Phone: 0300 123 6780  
Email: [developeras@lancashire.gov.uk](mailto:developeras@lancashire.gov.uk)  
Your ref: 3/2026/0045  
Our ref: 3/2026/0045/HDC/KW  
Date: 20 April 2026

**Location:** 70 Mellor Brow Mellor BB2 7EX  
**Proposal:** Proposed alterations to front boundary retaining wall including repointing, increase in height, new copings, steel railings along the top of wall and removal of existing hedge.  
**Grid Ref:** 364744 431015

**Elevation from Roadway - Proposed**

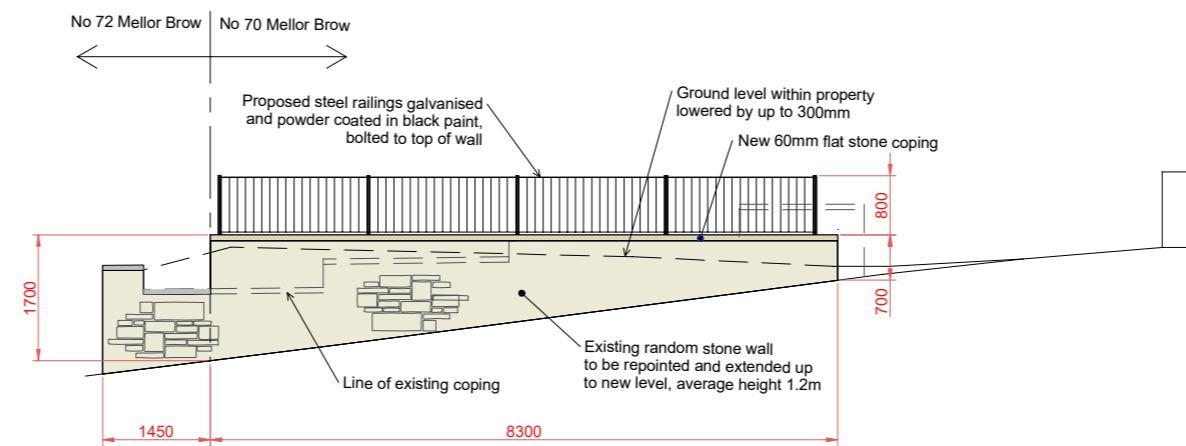
Whilst the proposal does not make a significant impact on the current visibility constraints, the LHA acknowledges that the removal of the vegetation which currently sits over the boundary wall will assist in improving visibility, which will be replaced with railings.
